Our ref: 3/2024/0943/HDC/KW

Date: 25 February 2025

Location: Black Moss Farm Elmridge Lane Chipping PR3 2NY
Proposal: Proposed erection of seven new agricultural buildings for dairy cattle and associated infrastructure including a covered midden and a wash down/fuel storage bay, associated hard standing and solar panels to south-facing roof slope and a new two-storey staff room/office building and two plant rooms.
Grid Ref: 360123 440456

Lancashire County Council acting as the Local Highway Authority (LHA) does not consider that the application as submitted fully assesses the highway impact of the proposed development and further information is required as set out in this response.

Access Road Section

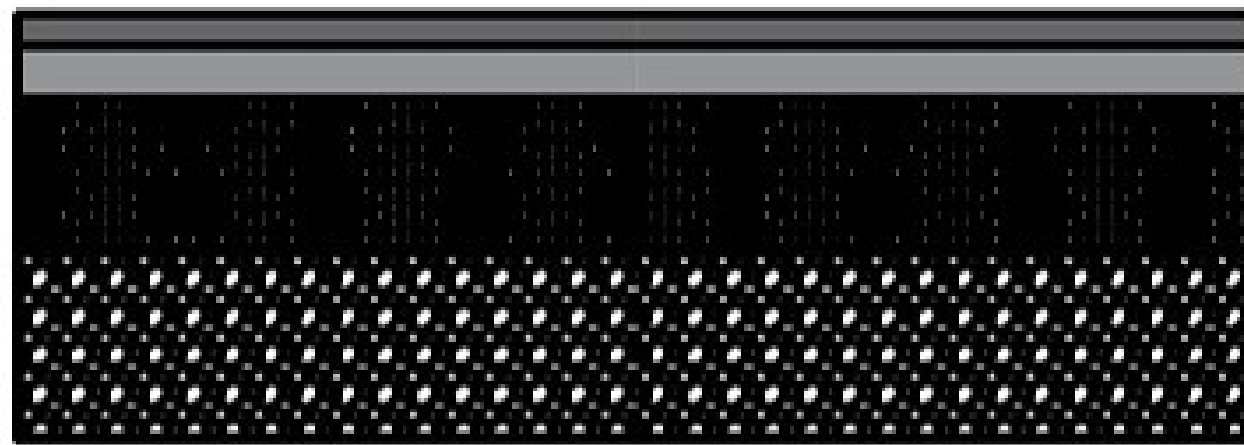
The LHA require a detailed access track drawing which clearly shows the width of the existing and proposed access track, information regarding any existing passing places should be included alongside any scope to create new passing places, particularly within the existing access track due to it serving several other properties. This is because the existing access track is approximately 280m long before it meets the proposed access track which leads to the development and following the proposal, more two-way movements could occur along the track.

Currently, the track appears to range in width with the smallest section being approximately 2.5m wide, therefore it's unlikely that two-way movements can occur at the same time. Therefore, following the intensification of use following the proposal, the LHA require either passing bays to be erected or the track to be widened.

The new access track is approximately 5.5m wide and is supported by a 25m radius turning area which will allow for large articulated lorries to turn within the site and leave in a forward gear.
